DECISION DELEGATED TO DEVELOPMENT MANAGER

Application No: H22-0731-19 **Applicant:** Broadgate Homes
Proposal: Erection of 6 dwellings (details of layout) - outline approval H22-0218-16
Location: Pinfold Lane Weston Spalding
Terminal Date: 30th November 2019

Drawn By: JT Drawing No: **0908-CONS-01** Scale: 1:250
Date: November 2017 Rev: D Date: 09.10.19

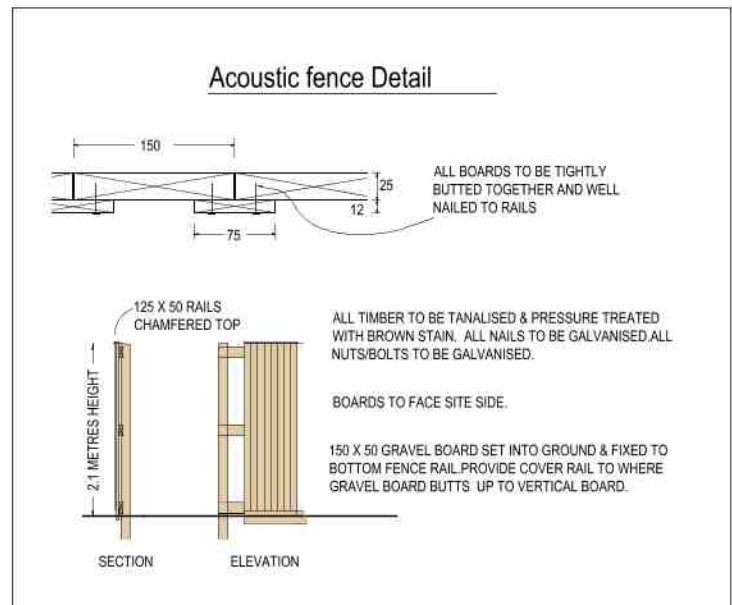
Moving the dwelling eastwards within Plot 3 would reduce the separation distance to the property to the east from 9m to 7.8m. The dwelling in its new position would be approx. 3.9m from its boundary. This is a satisfactory separation distance.

In addition to the above, it is proposed that the railings at the southern part of the site be relocated approx. 0.6m nearer the boundary than previously. This would have no discernible impact and is therefore acceptable.

The private pumping station is proposed to be upgraded to an Anglian Water pumping scheme. No concerns are raised regarding this.
